KITTITAS COUNTY COMMUNITY DEVELOPMENT SERVICES

January 19, 2018

Subject: Final Planned Unit Development for the Hyak Amended PUD (File Z-87-00002 & Z-93-00003) – Staff Review and Request for Additional Information

RE: Hyak PUD Final Development Plan REVISED COMMENTS

DEVELOPMENT, STORMWATER AND PARKING PLAN - PARCEL A

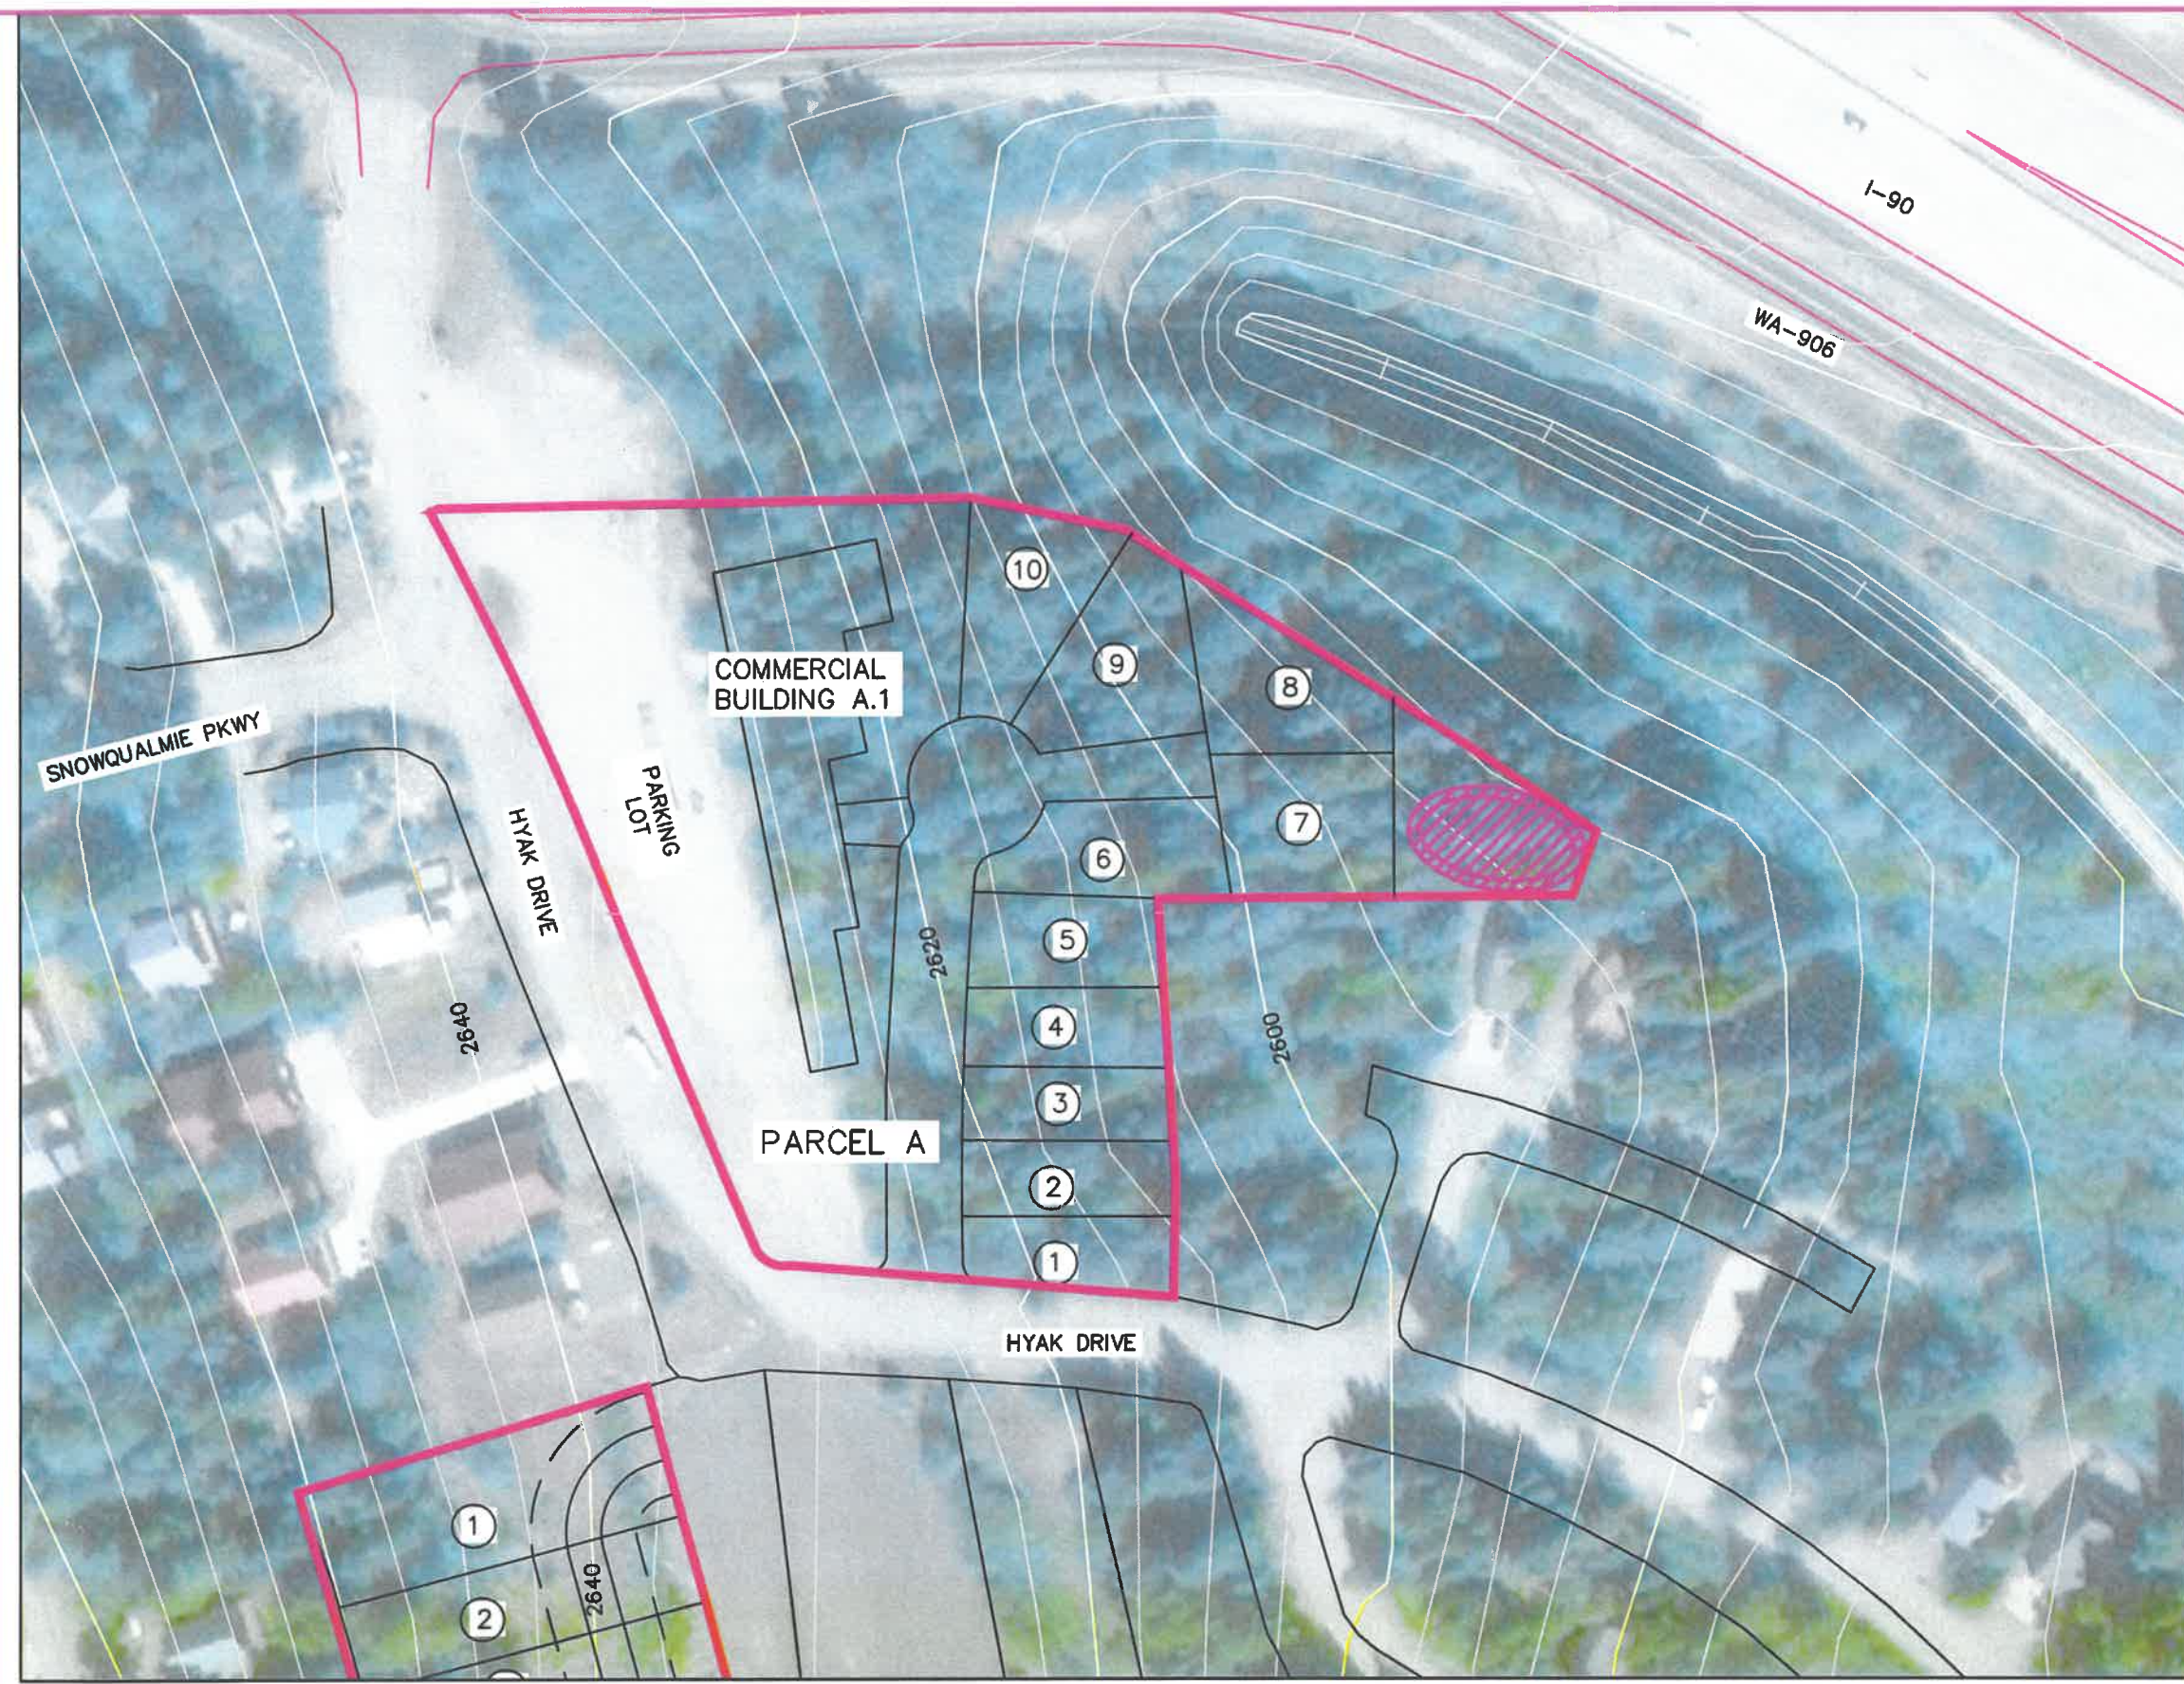
Please provide updated mapping either with a key or identification on each building regarding the type/use. The map also needs to be updated to show contours to understand the preliminary storm drainage plan; this will provide some basic information as to whether the locations the storm water facilities shown on the site plan are feasible.

3. The proposed 25 underground parking stalls supporting the commercial use element in Parcel A (20,000 SF) is inconsistent with ITE data on commercial uses generating travel demand. A commercial apparel store is estimated to develop and average of 4 trips per peak hour per 1,000 SF. This suggests a potential of 80 peak hour trips with only 25 parking stalls. The developer is encouraged to refine the commercial land use proposal and provide sufficient parking supporting the actual commercial use. Specific parking demand will be evaluated during final plat submittal.

5. Stormwater treatment and storage prior to discharge are significant issues in Hyak. The terrain is not conducive to large facility size. Attempting to site a storage pond on a side slope creates issues associated with compacted fill on the downslope side of the pond. The suggested size of the majority of stormwater ponds (Parcels: A, B and F) appears to be problematic given the terrain of Hyak. The lack of contour data does not assist in evaluating the feasibility of the proposal.

HYAK SNOW STORAGE EXHIBIT

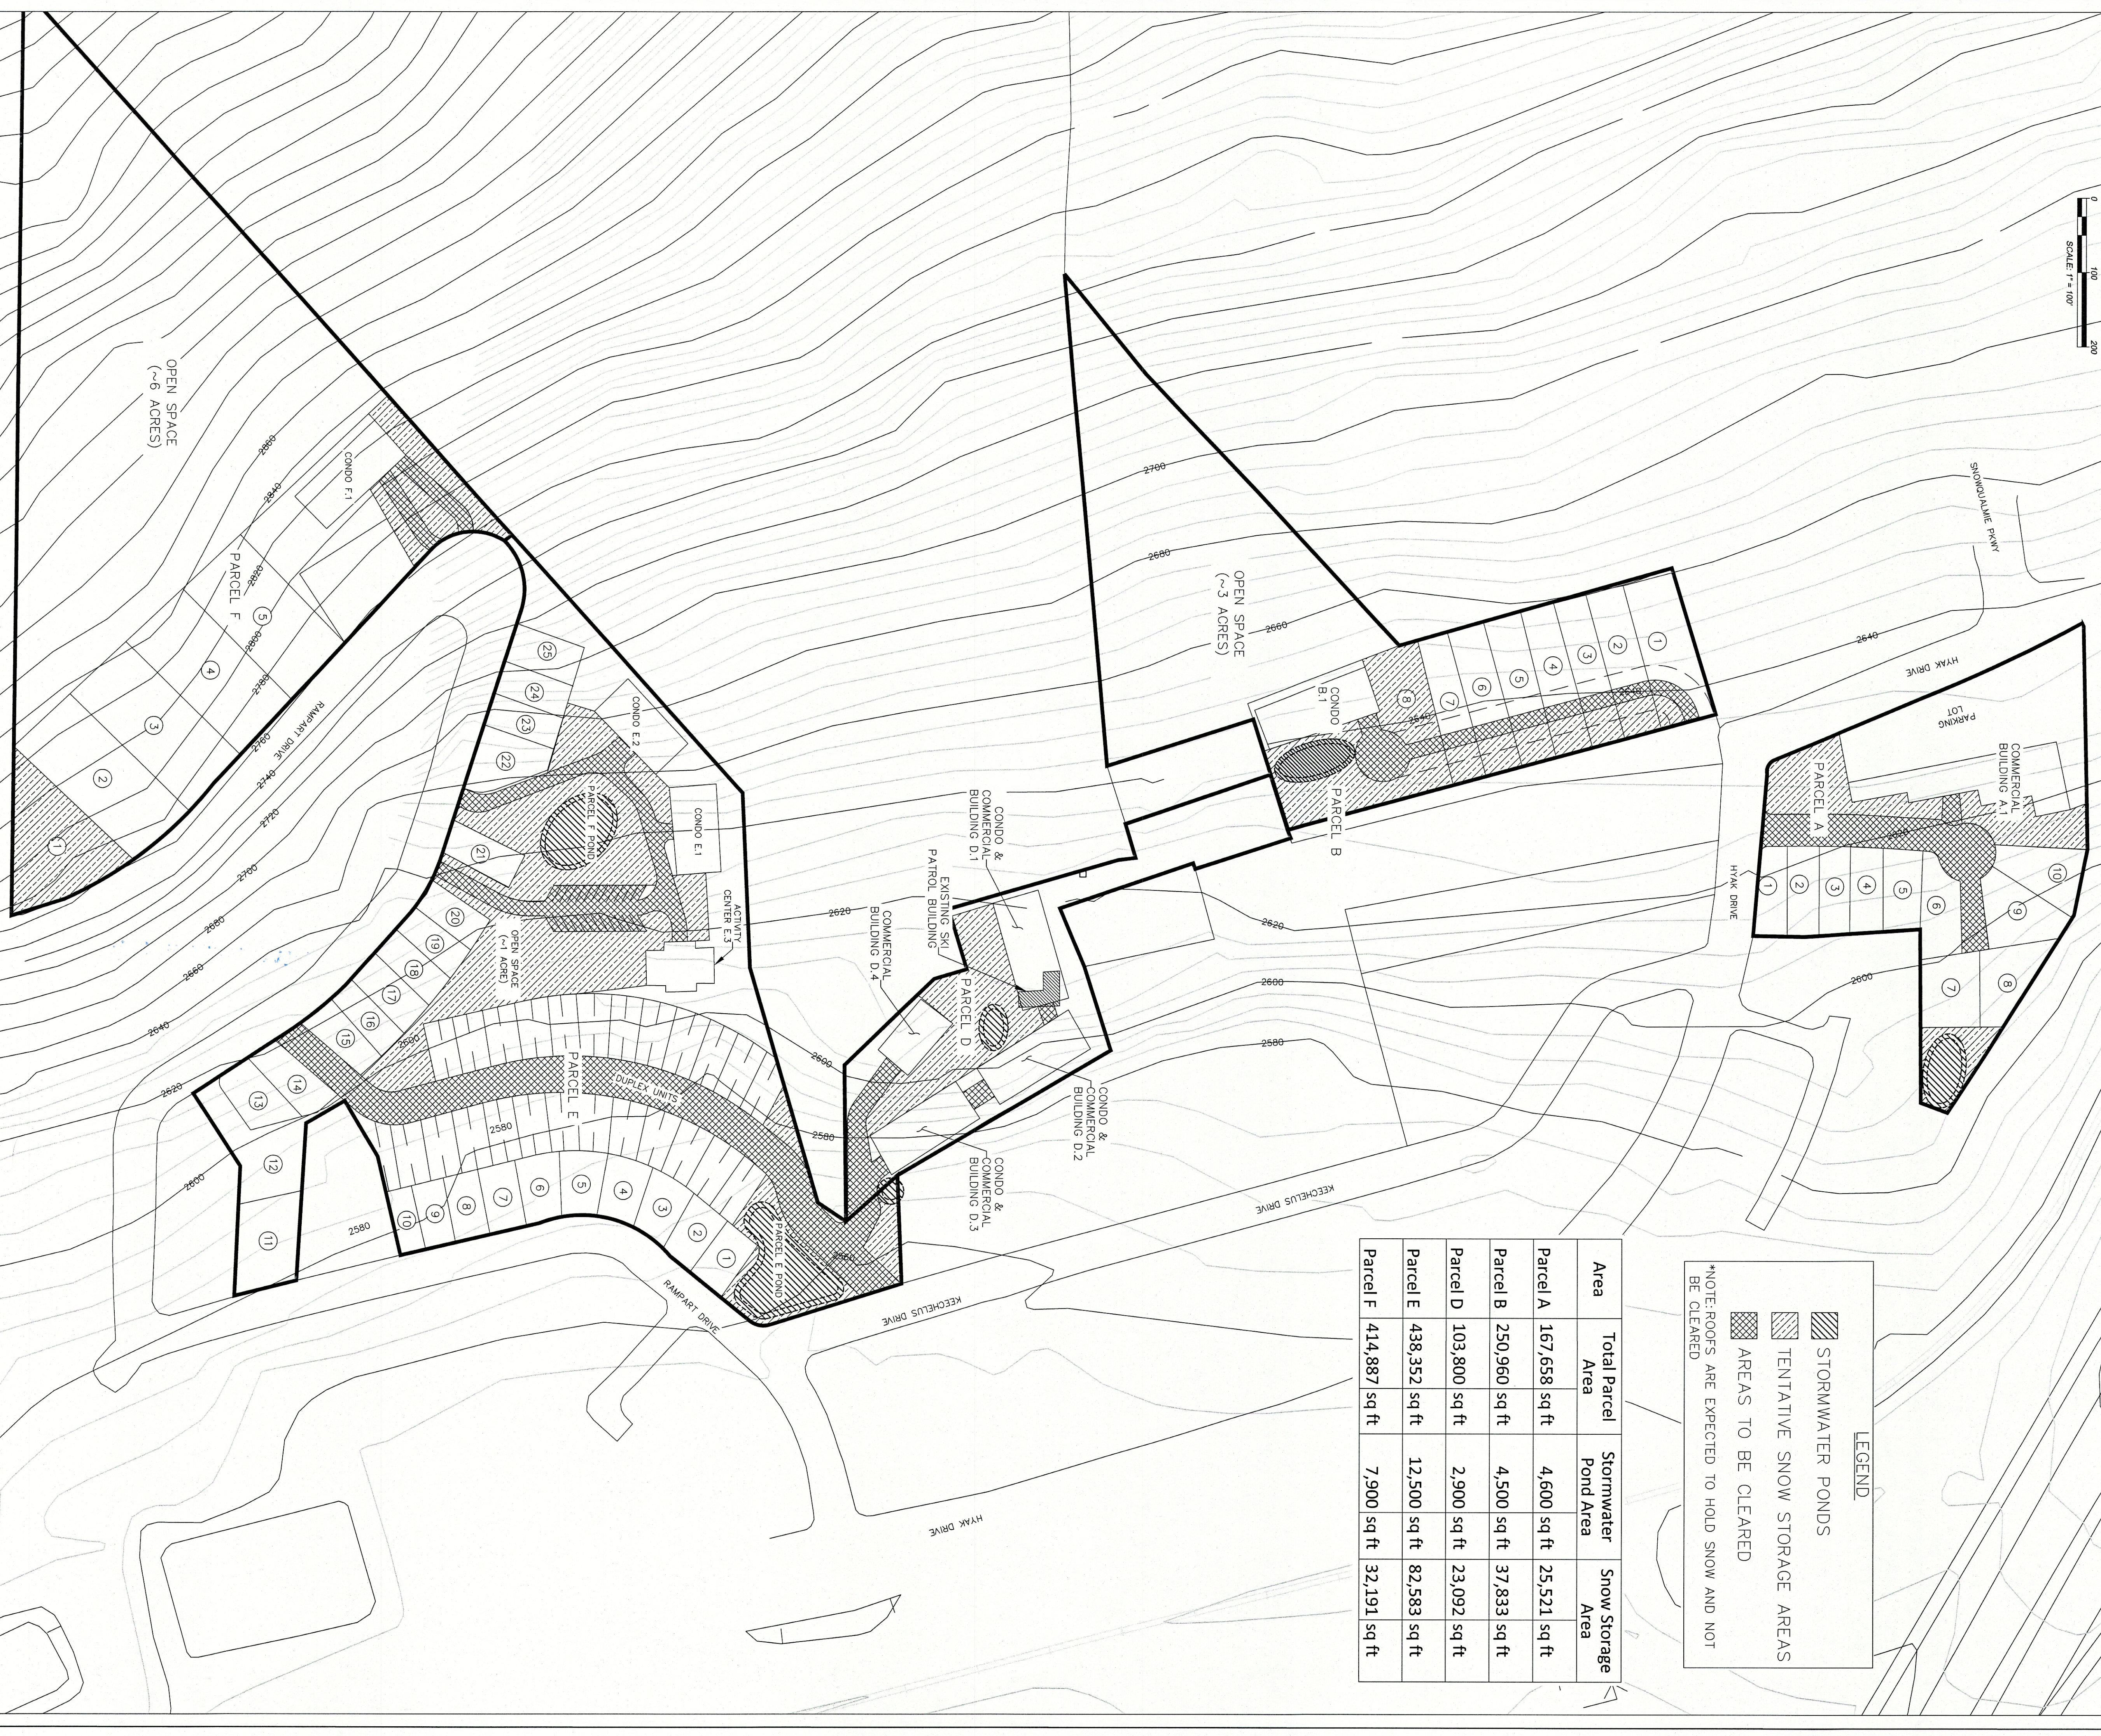
1. Public Works is experiencing increasing inability to remove snow within the Hyak Community. The issue is development of vacant parcels eliminating the ability to target our snow blowers. The proposed development will exacerbate this condition. It is likely that at some point in the near future, property owners in Hyak will be required to participate in mandatory Road Improvement District (RID) addressing increasing maintenance costs associated with snow removal. The exact specifics of snow removal and storage will be addressed during final plat submittal.

6. Proposing snow storage in stormwater ponds is problematic given that the facilities will likely be much smaller in final design than the conceptual plan as provided. Presuming snow storage in stormwater ponds is possible, spring runoff will likely result in area flooding as the ponds will not be available for snow runoff water. The lack of contour data does not assist in evaluating the feasibility of the proposal.
